Lester Short Plat

File Number SP-07-44

RE: Re-Notification of Conditional Preliminary Approval, Lester Short Plat, File Number SP-07-44

DRAWN BY: M.M. SCALE: 1" = 100'
CHECKED BY: D.S.G. DATE: 11-01-06
PROJECT NO. 06208 SHEET 1 OF 2
PARCEL NO. 18-19-12000-0004

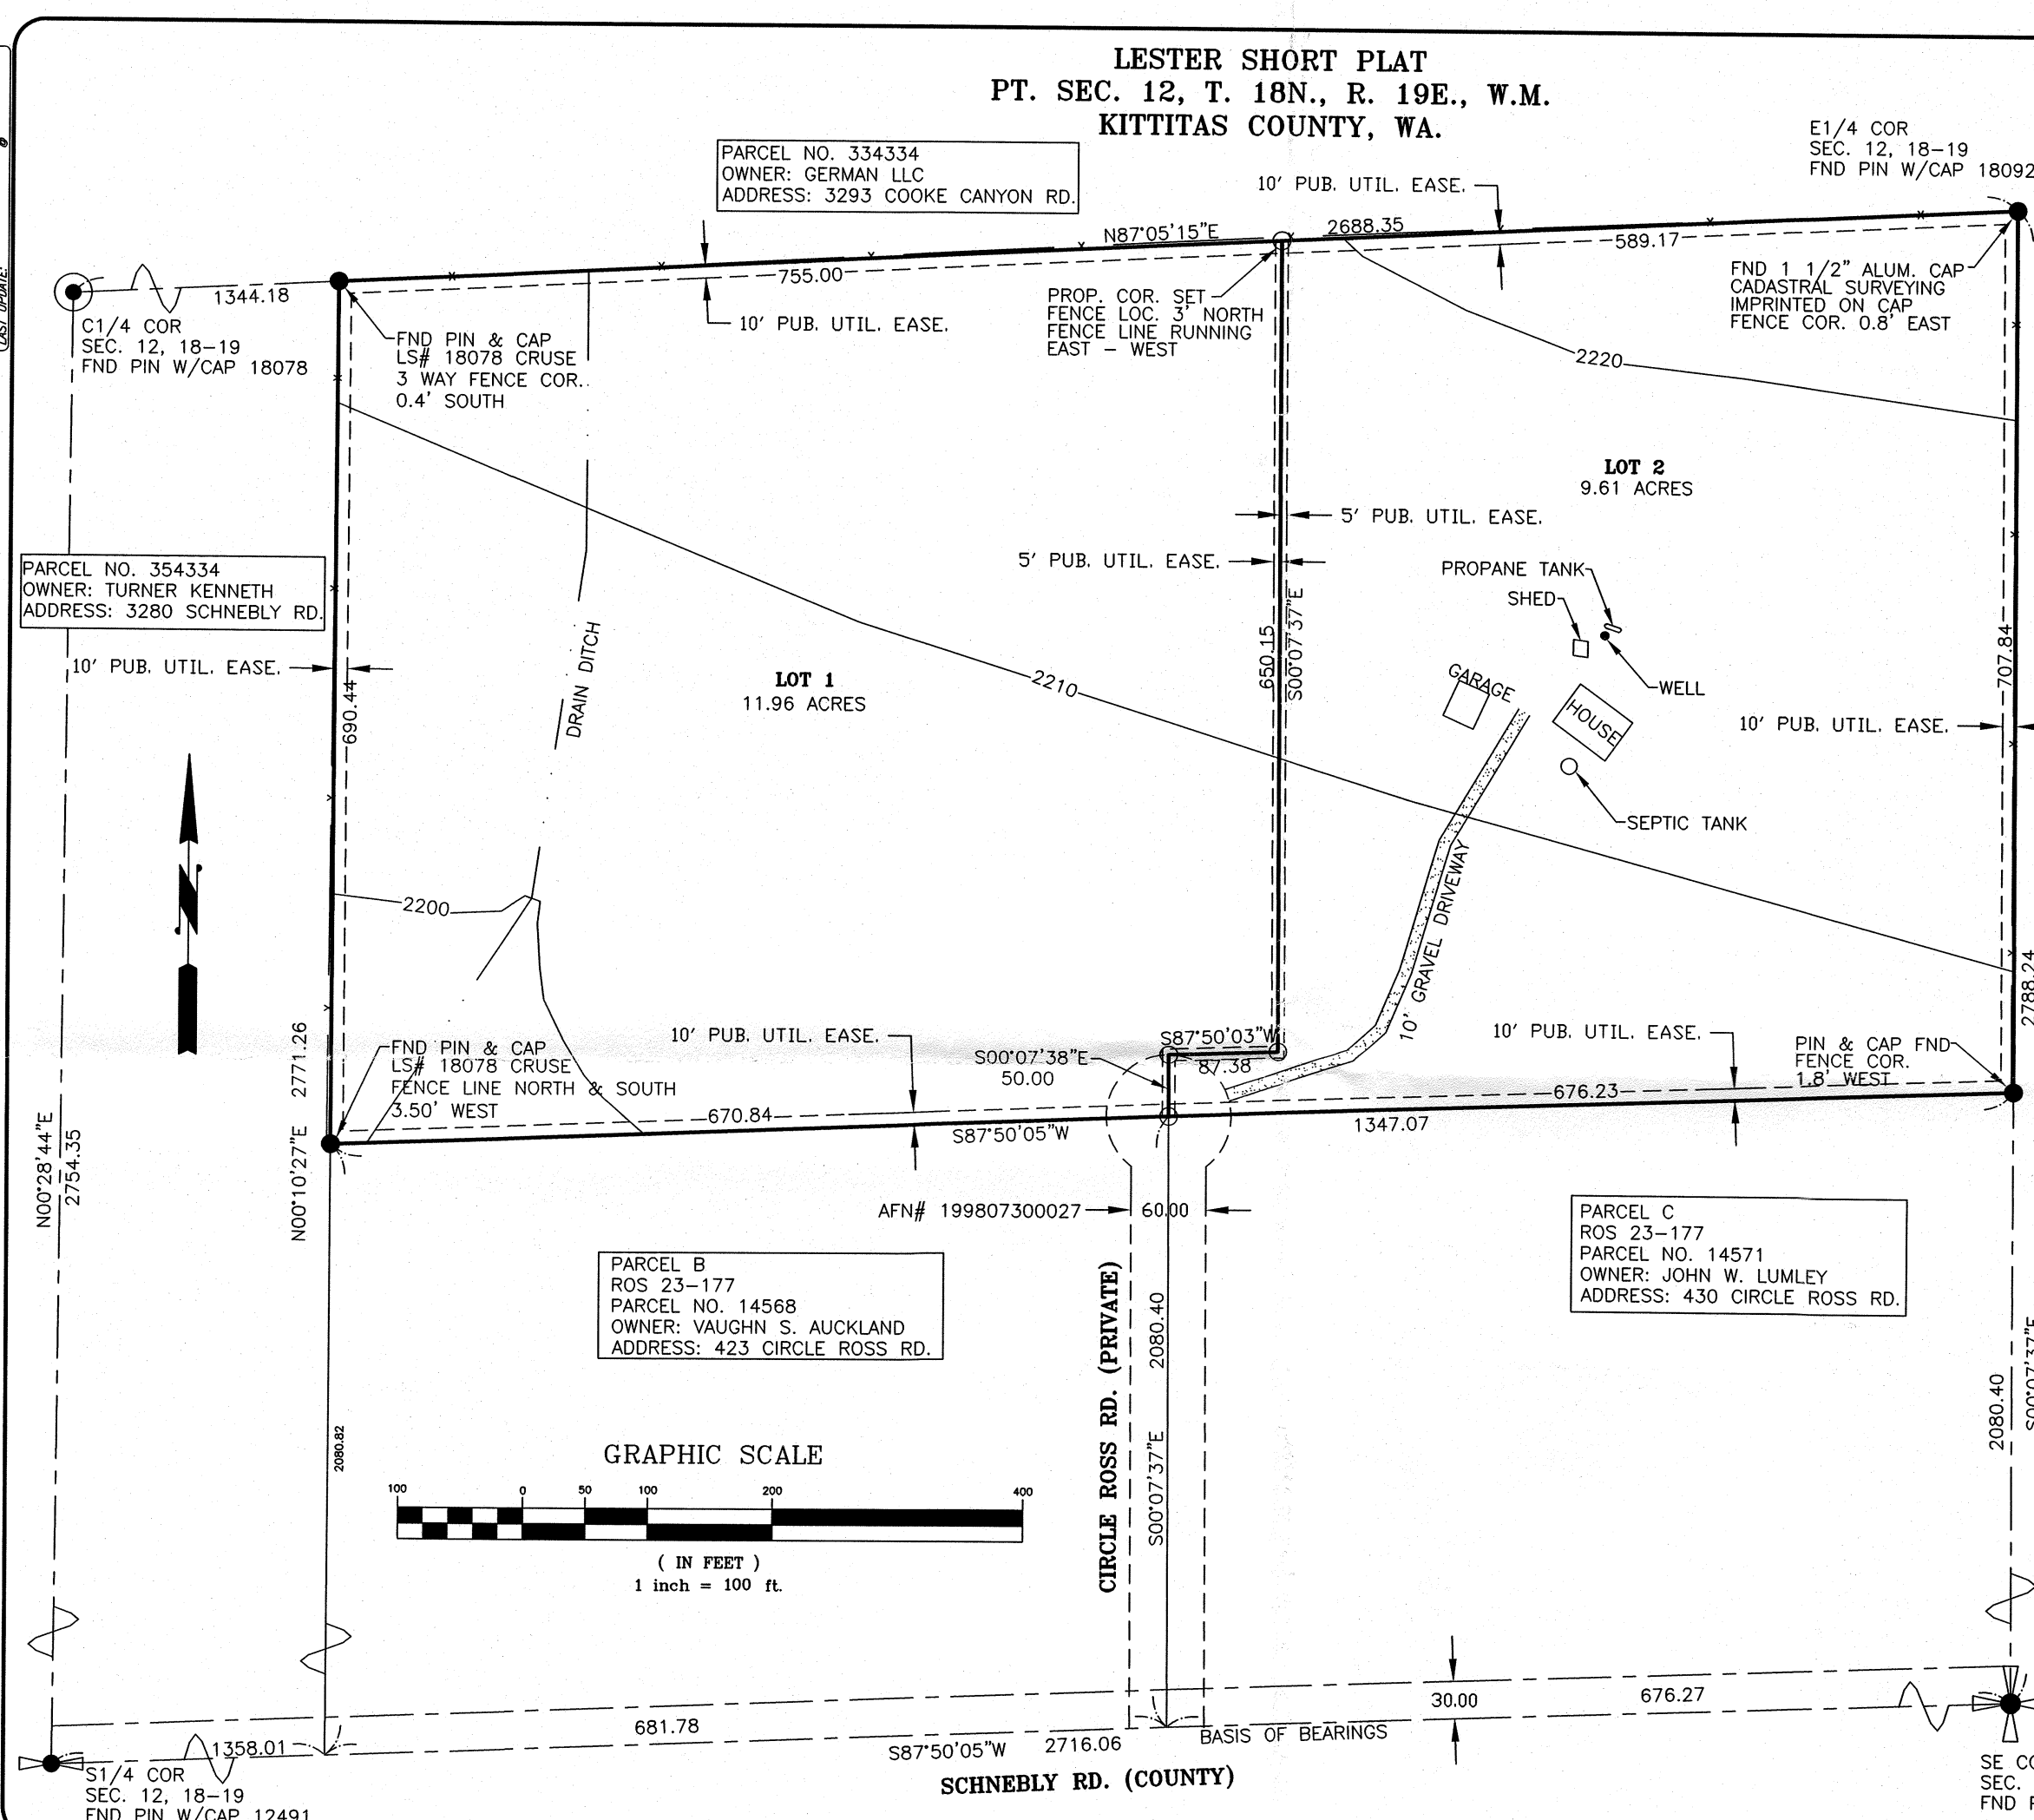
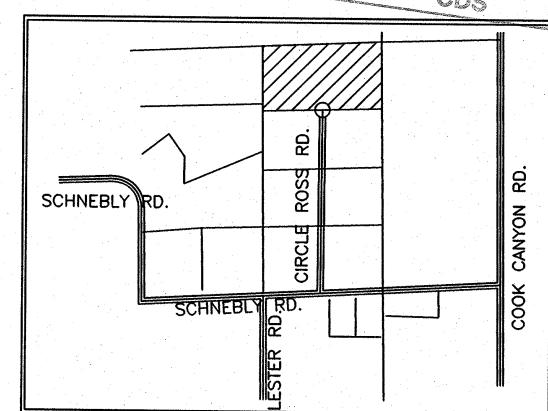
- 1) Both sheets shall reflect the Short Plat Name "**Lester**" and Short Plat Number **SP-07-44** at the top of all sheets, followed underneath by the section, township, range, county and state.

- 2) The road mislabeled as "Cook Rd." in the vicinity map on the first page of the plat drawings shall be changed to reflect the correct name of the road, which is "Lester Rd."

- 3) Critical Areas: Lot 1 of the Lester Short Plat has a PEMC wetland (Palustrine Emergent Seasonal) located on the southeast portion of the lot. The final mylars shall reflect the location of this wetland, and a statement on the plat shall read as follows:

- 4) The first page of the final mylars shall display a labeled space in the upper right hand corner in which to record the Receiving Number of the Short Plat.

- 5) In the Signature block reserved for the Kittitas County Public Works Department on the first page of the Short Plat drawings, the phrase "Kittitas County Public Works" which is currently displayed beneath the signature line shall be changed to read "Kittitas County Engineer".

- 8) The property owner's name shall be clearly labeled on the first page of the final plat drawings.
- 9) Plat notes employing the following phrasing and providing the required information (highlighted here in bold font) shall be present on the second sheet of the plat drawings in the portion labeled "Notes":
